Subject: BL-23-00019 Smith

We are processing your Boundary Line Adjustment and we are going to need some additional materials added to your site plan in order to be able to deem your application “complete” and move forward with the process of reviewing it with other departments.

**PRELIMINARY BOUNDARY LINE ADJUSTMENT**

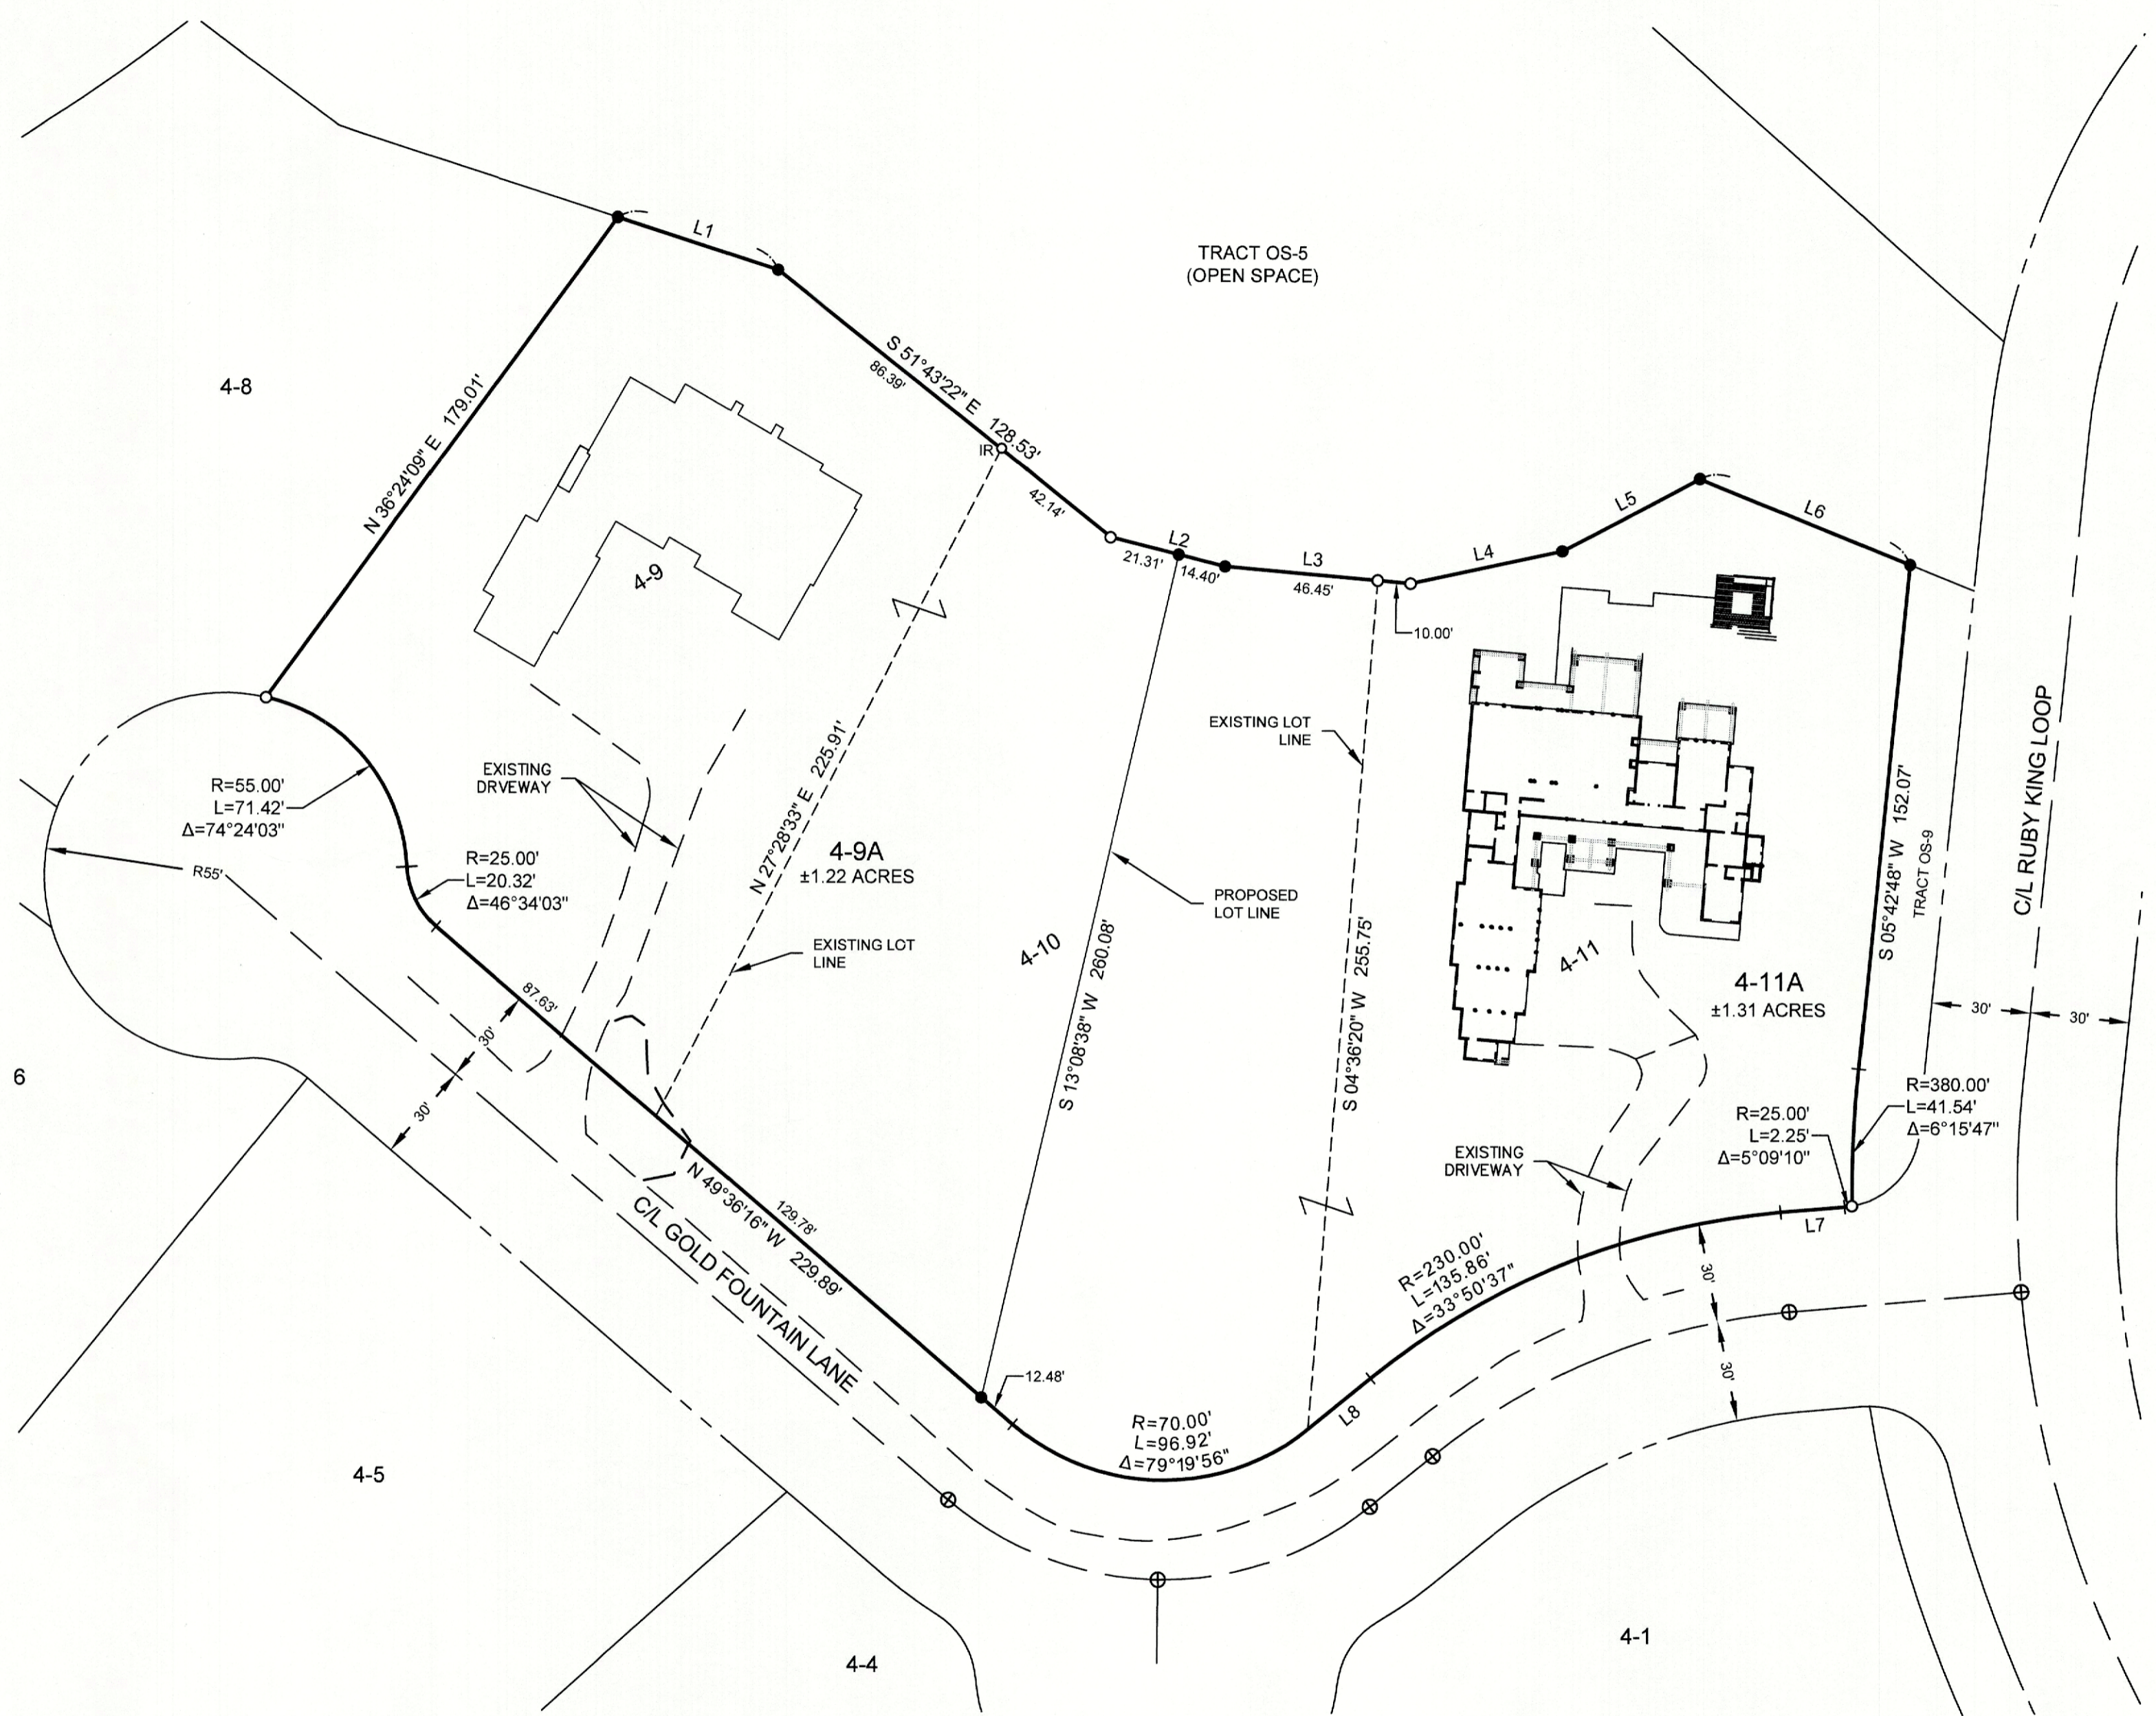
Please add the following elements to your site plan:

Distances to proposed boundary lines from all existing structures.

- Well heads and septic systems/drainfields also need to be represented on the map.

We can certainly add the dimensions as requested however, the Tumble Creek development is served by a Class A potable water system and a Sanitary Sewer system. As such, there are no wells, or septic/drainfields on these properties.
